Project Name: JOURNAL CENTER PHASE 2, UNIT 1

08DRB-70200 – SITE DEVELOPMENT PLAN FOR BUILDING PERMIT

DEVELOPMENT REVIEW BOARD--SPEED MEMO

HANCOCK OFFICE BUILDING
 SITE PLAN
 ALBUQUERQUE, NEW MEXICO
 PROJECT #0761

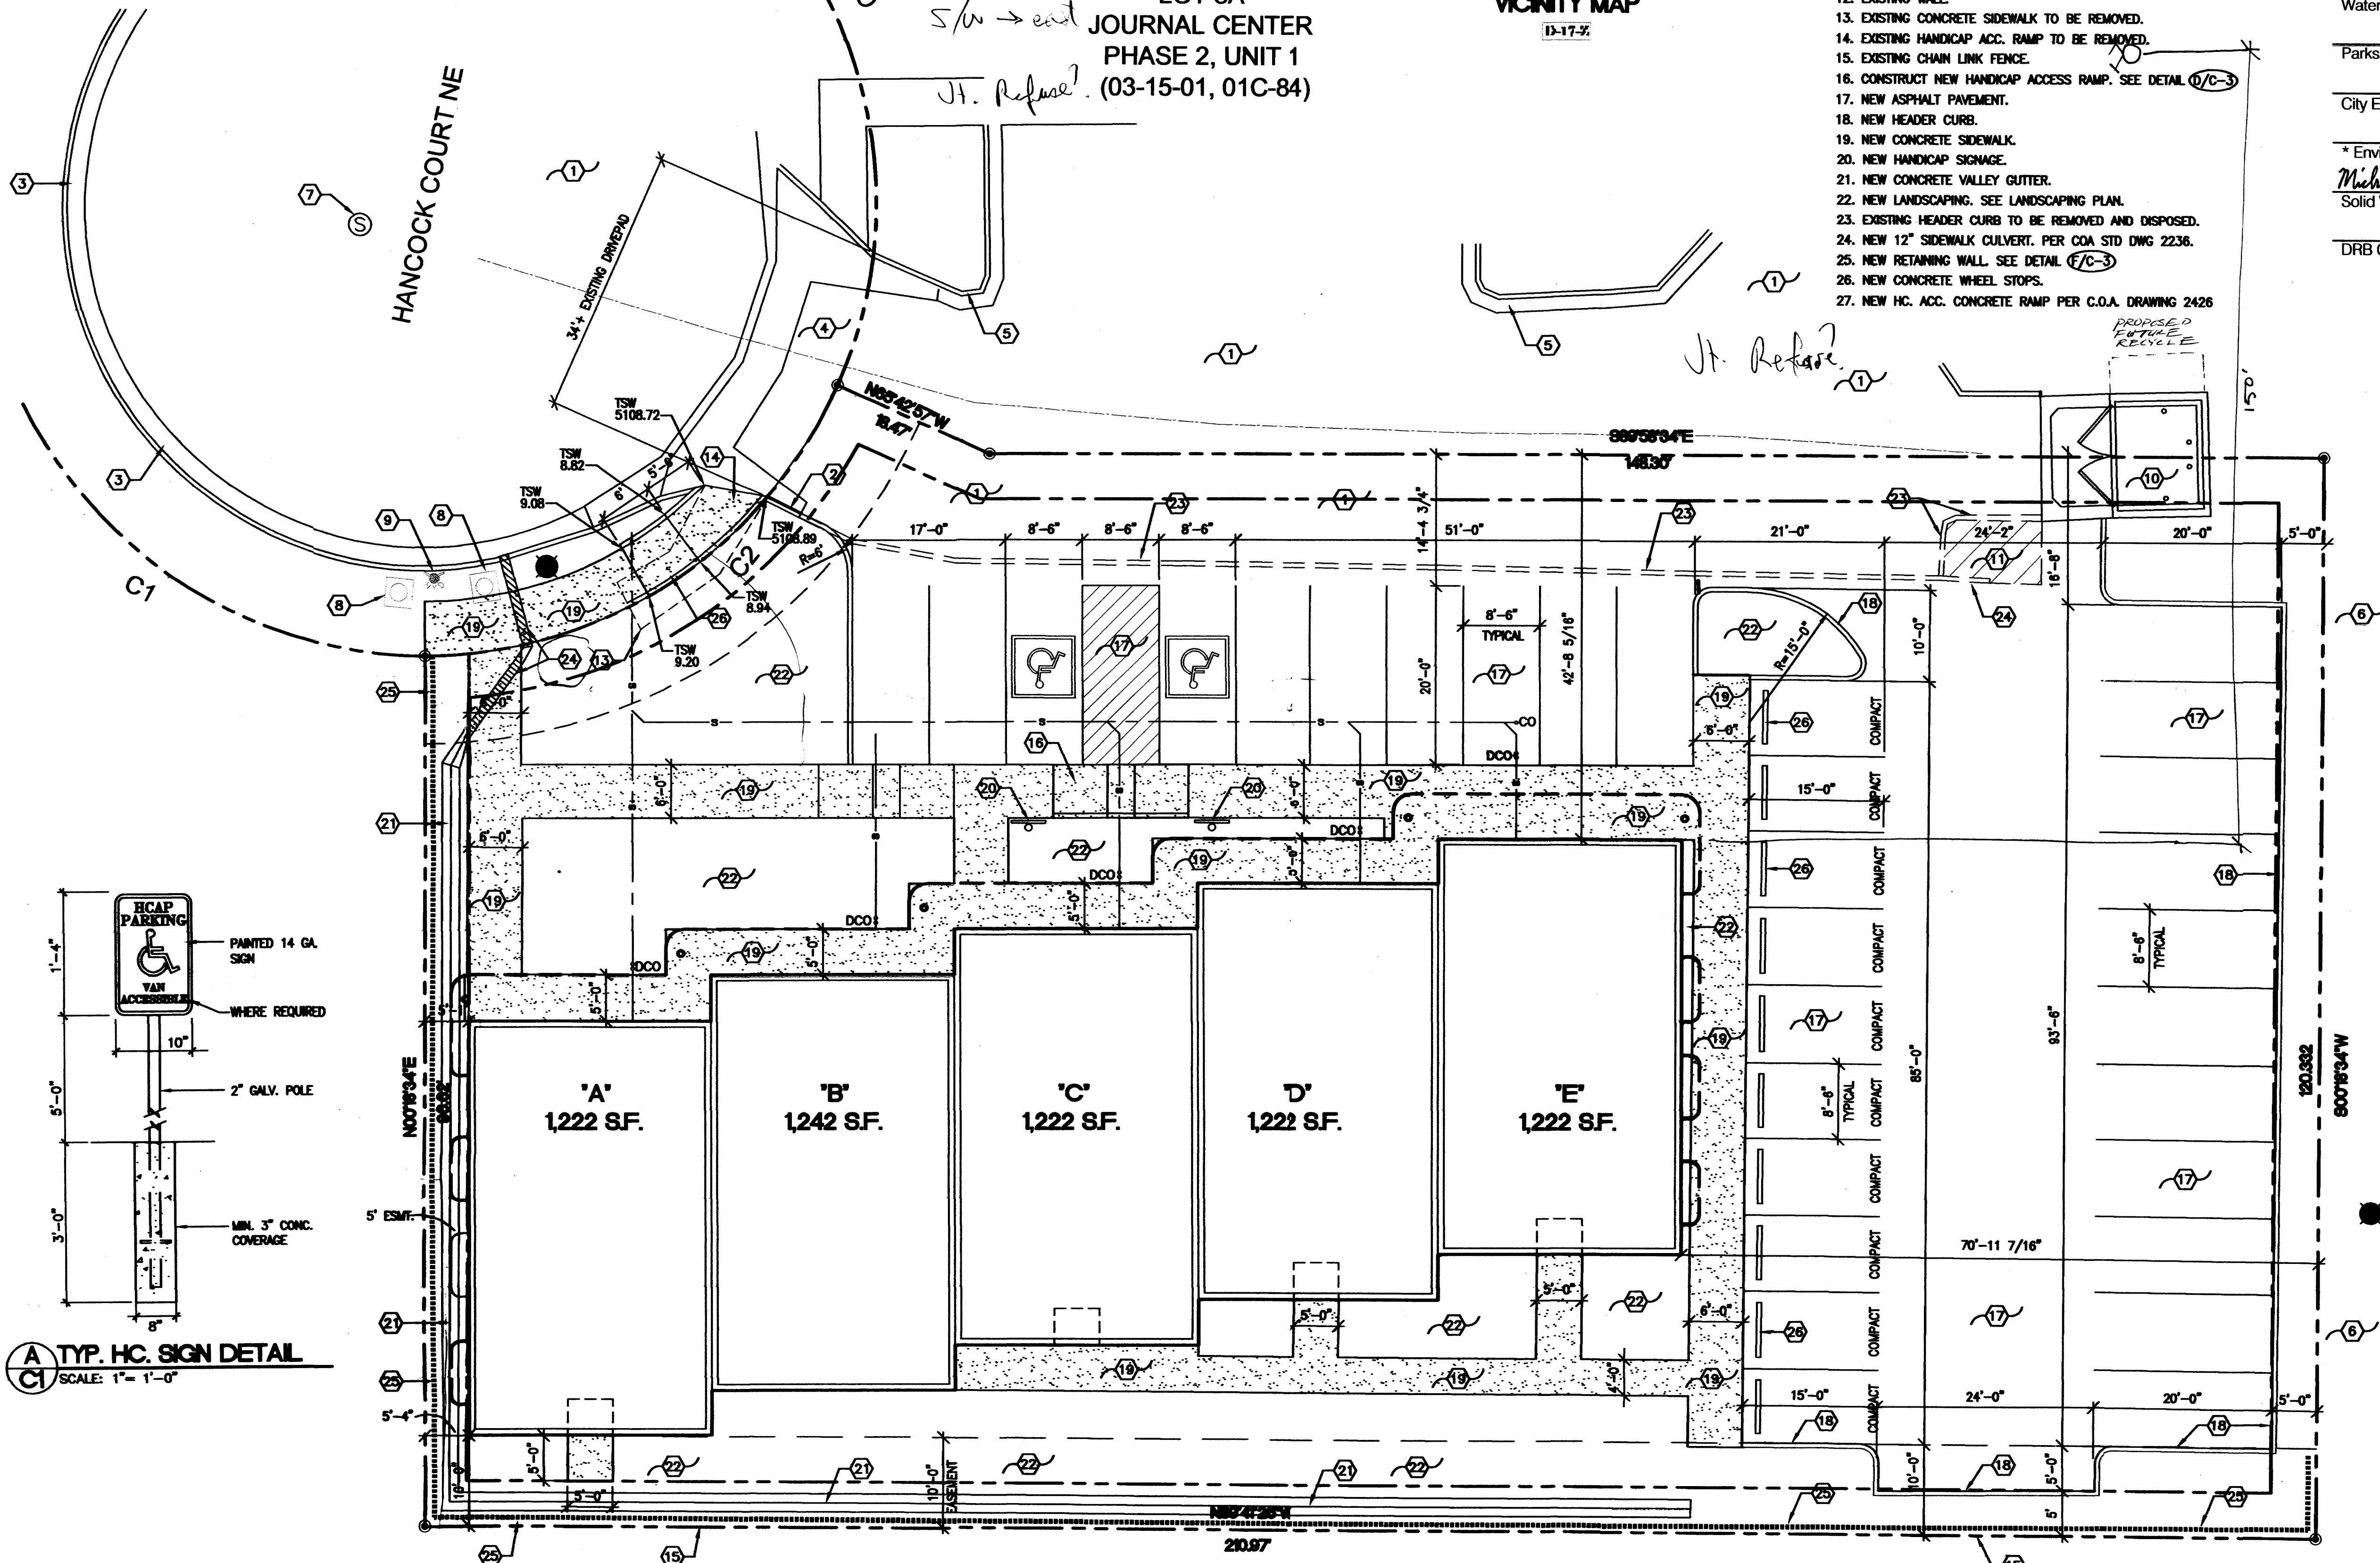
PLANNING (Last to sign): Journal Center Architectural Comm approval
revise S/W

OPEN SPACE DIVISION Open space has no adverse comments.	RB RB
CITY ENGINEER No adverse comments.	RB RB RB
TRANSPORTATION DEVELOPMENT No comments received.	
PARKS AND RECREATION No objection.	
ABCWUA What size is existing water service, and what size meter is needed? Where is the 2 nd required fire hydrant?	
PLANNING DEPARTMENT The pedestrian connection to the street should be moved from the west property line to the west edge of the parking lot. Motorcycle parking is required per the Zoning Code. A copy of any joint use agreement for refuse is needed for this file.

AMAFCA No comment.
COG MRCOG staff have no comment on this proposed development.
TRANSIT No comments received.
ZONING ENFORCEMENT Motorcycle parking & signage? HC Signage? Bicycle rack?
NEIGHBORHOOD COORDINATION Letters sent to: Alameda North Valley Assoc. (R)
APS Journal Center Phase 2 Unit 1 , Lot 7A, is located at the southern terminus of Hancock Ct NW south of Wolcott Ave NW. The owner of the above property requests approval of a Site Development Plan for Building Permit for a development that will consist of an office complex. This will have no adverse impacts to the APS district.
POLICE DEPARTMENT Lighting issues: Steps should be taken to remove conflict between proposed lighting and landscaping, particularly adjacent to parking areas, walkways and building entrances. Maintenance of landscaping: Landscaping should consist of low level variety plants. Trees and plants should be away and clear from buildings. Landscaping should not restrict visibility from walkways, parking areas and buildings entrances/exit points.
